**Consultation Response from KC,
Trees**

2026/90521 2, Foxglove Road, Almondbury, Huddersfield, HD5 8LW

Erection of extensions and alterations

01	Revision to scaling of Site Plan 1/500	06 Jun 26
00	Original	24 Jan 26
Revision	Note	Date
Project: 2 Foxglove Road, Almondbury, Huddersfield		
Title: Site Plan - Proposed		
Scale: @ A3		Date: 06 Jun 26
Drawn By: JAG	Drawing Number: Fox/jg/PI/009	Revision: 01

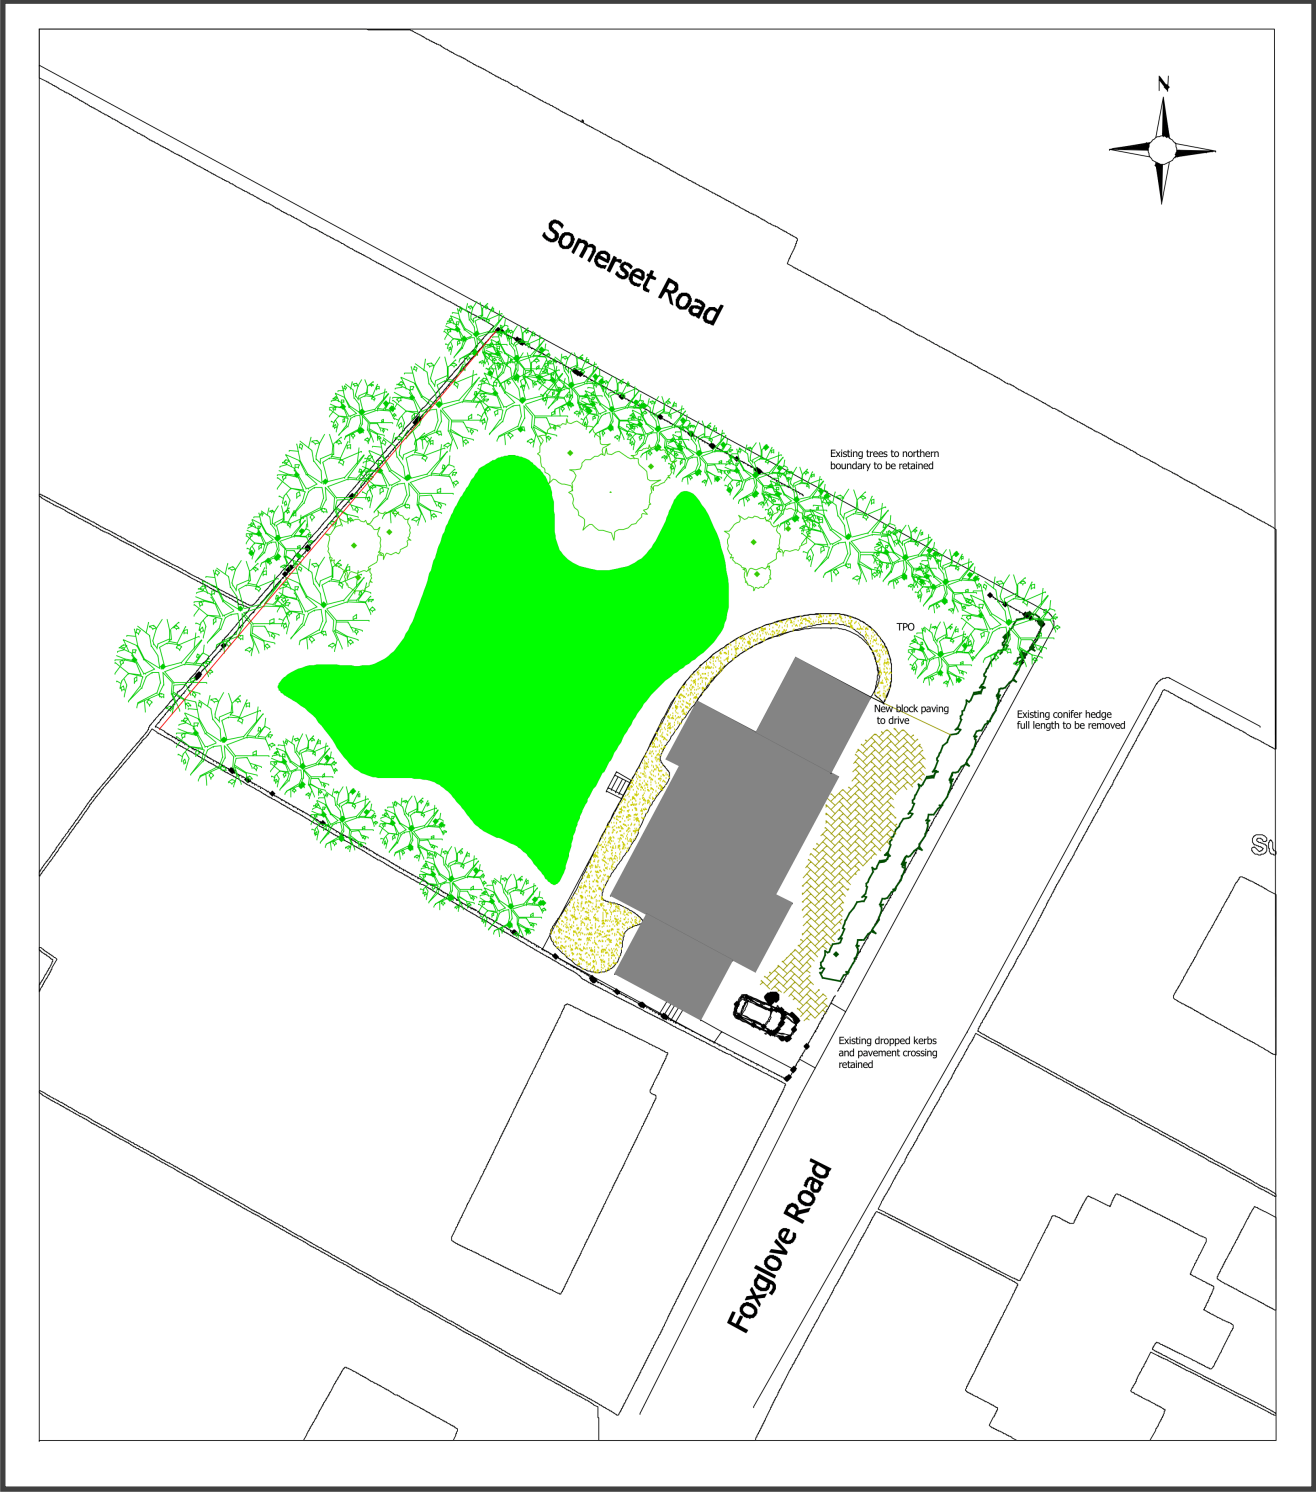
There is a TPO present on the tree closest to the planned extension. It appears that other TPO trees have historically been removed but not replanted.

Due to the proximity of the planned extension to the TPO'd tree there is likely to be some impact on the tree's root system when digging the extensions foundations. This would restrict the tree's ability to source water and nutrients in the future and could eventually lead to its death.

There must be an Arboricultural Impact Assessment (AIA) submitted which accurately shows the level of impact on the protected tree and any special engineering that may be required for the building and tree to co-exist.

There is a holding objection until the requested document is submitted for review.
